From: Simon Davis
Sent: 28 August 2018 16:23
To: Planning Scanning
Subject: FW: P/49/18/HH 39 Conway Drive Pagham

From: Simon Davis
Sent: 27 June 2018 12:24
To: 'Anonymous Guy'
Subject: RE: P/49/18/HH 39 Conway Drive Pagham

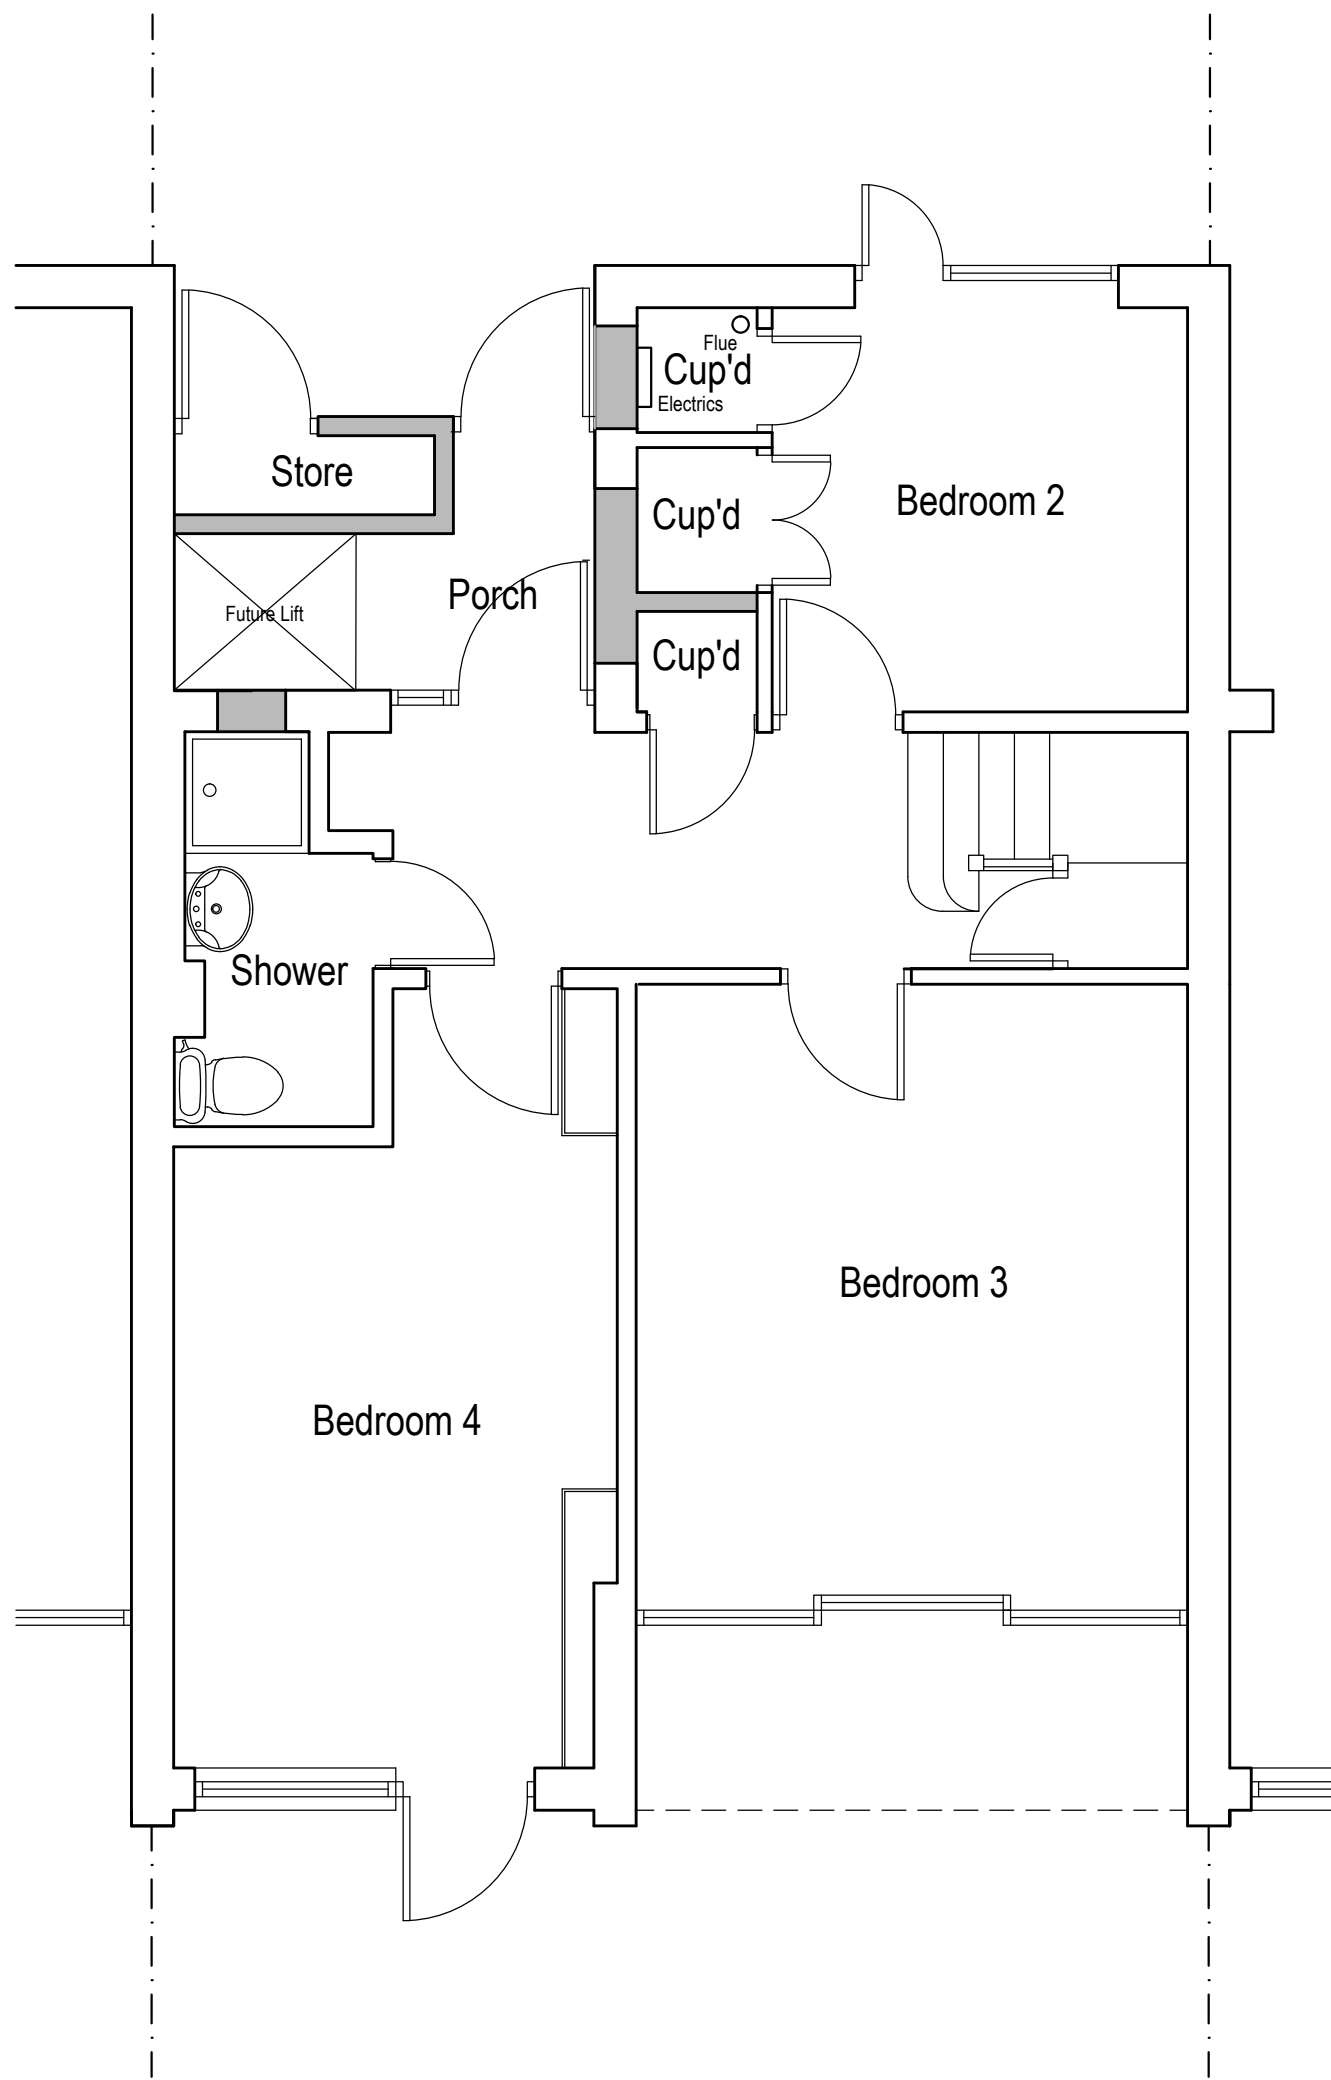
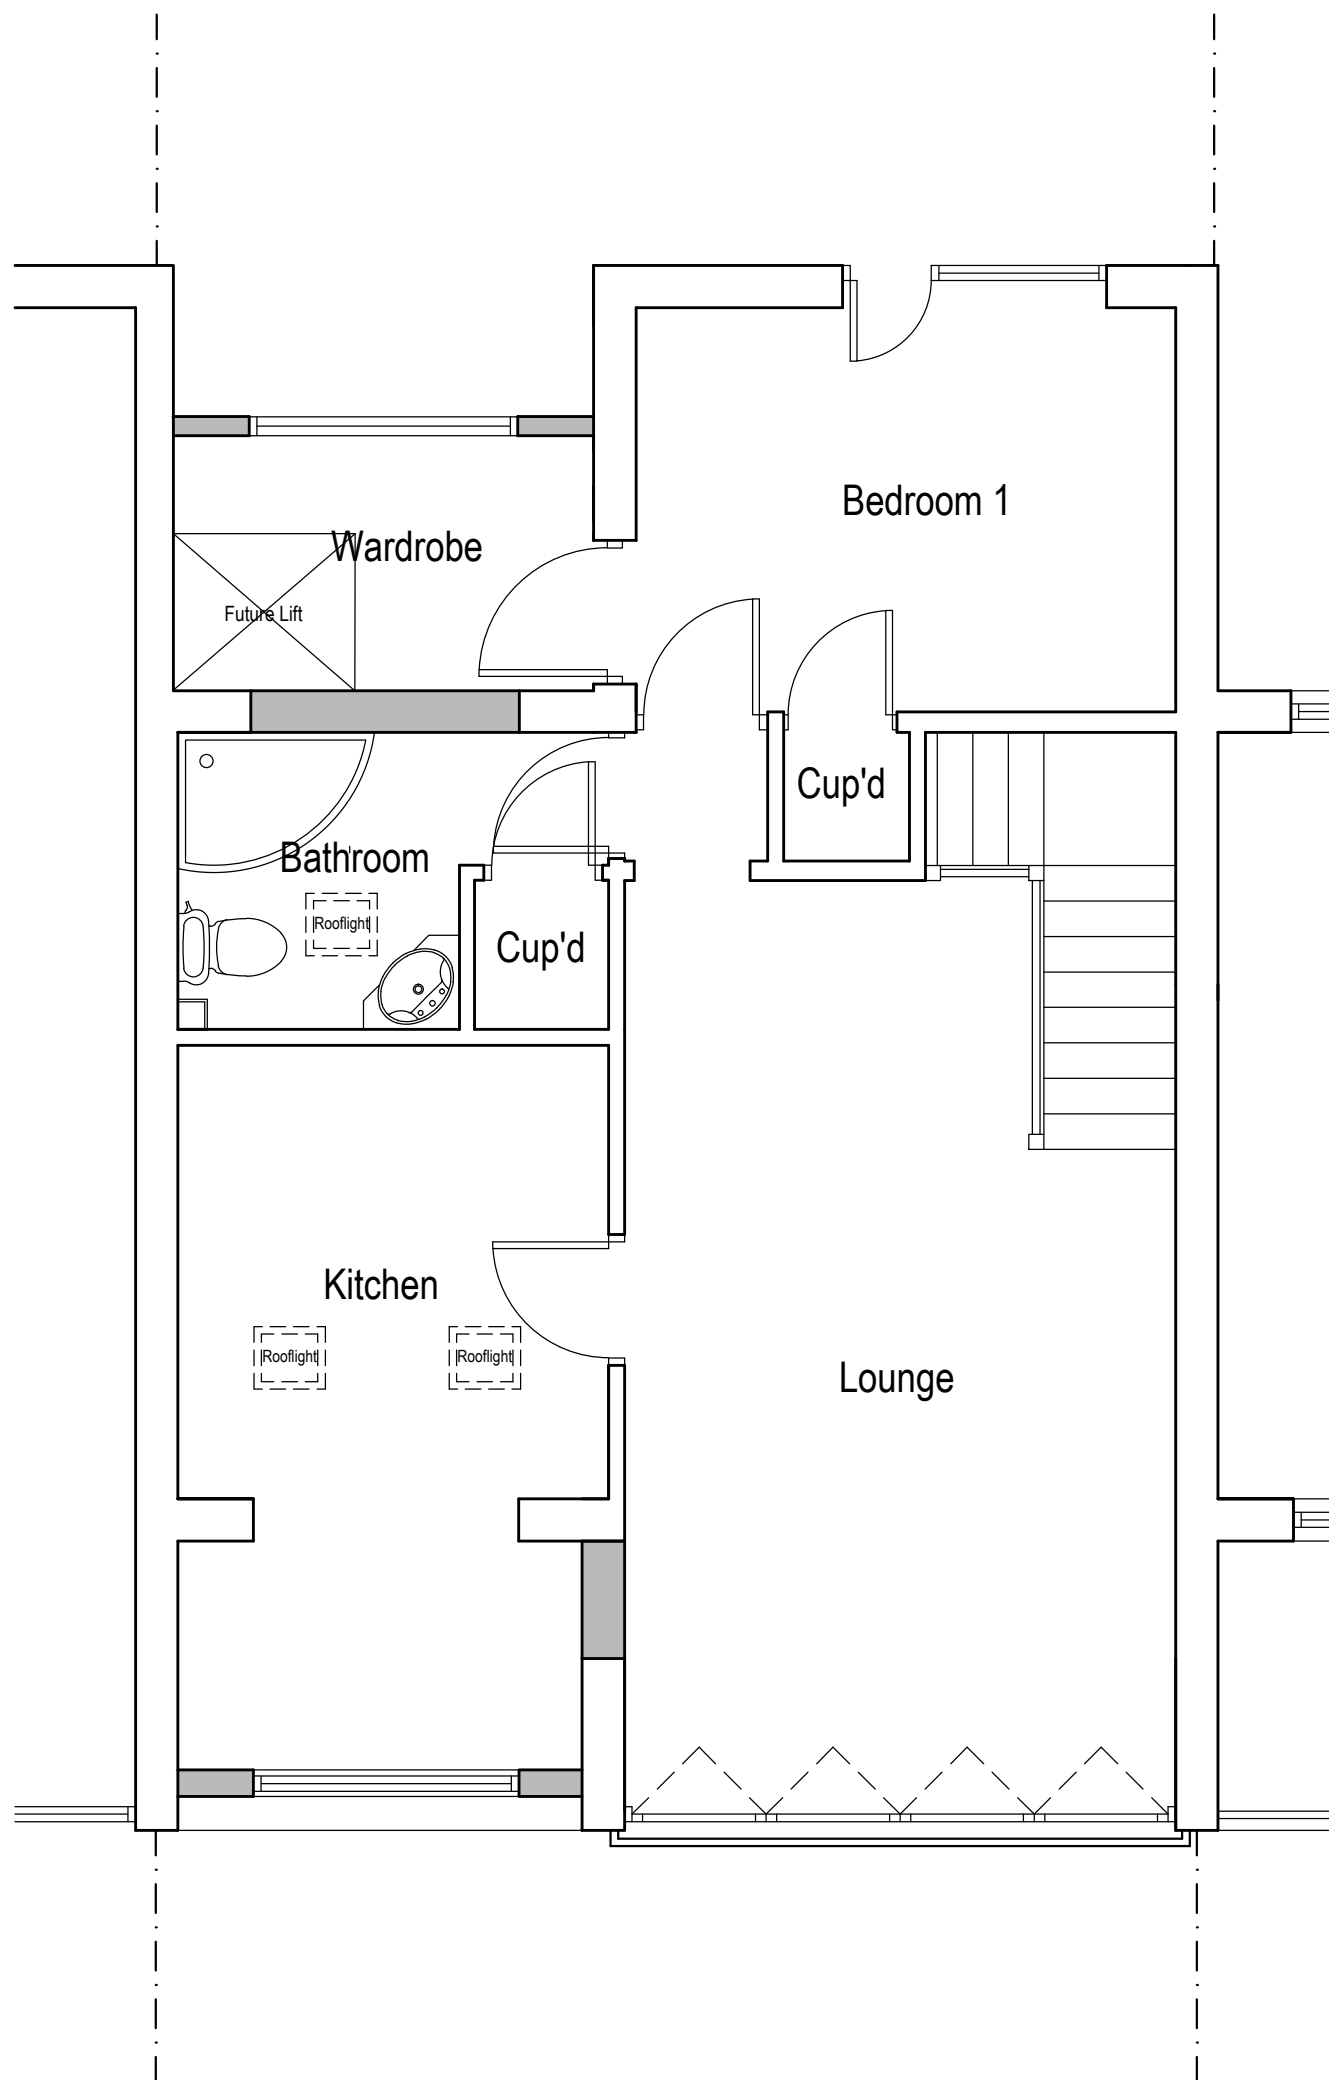
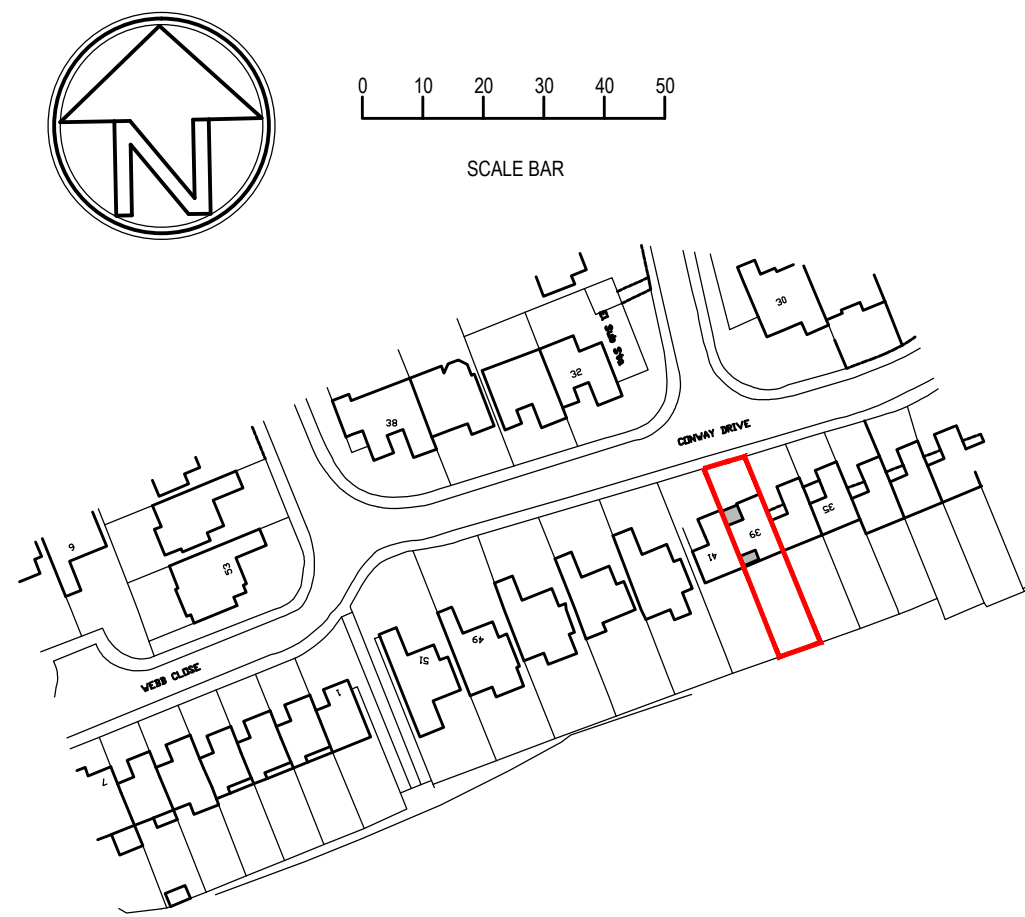
I have had a conversation with my team leader about the extensions and we feel that we can support them only if the new front extension is set at least 1m back from the existing front (at both ground & first floors). Please can you raise this with your client and advise whether he can agree to this change.
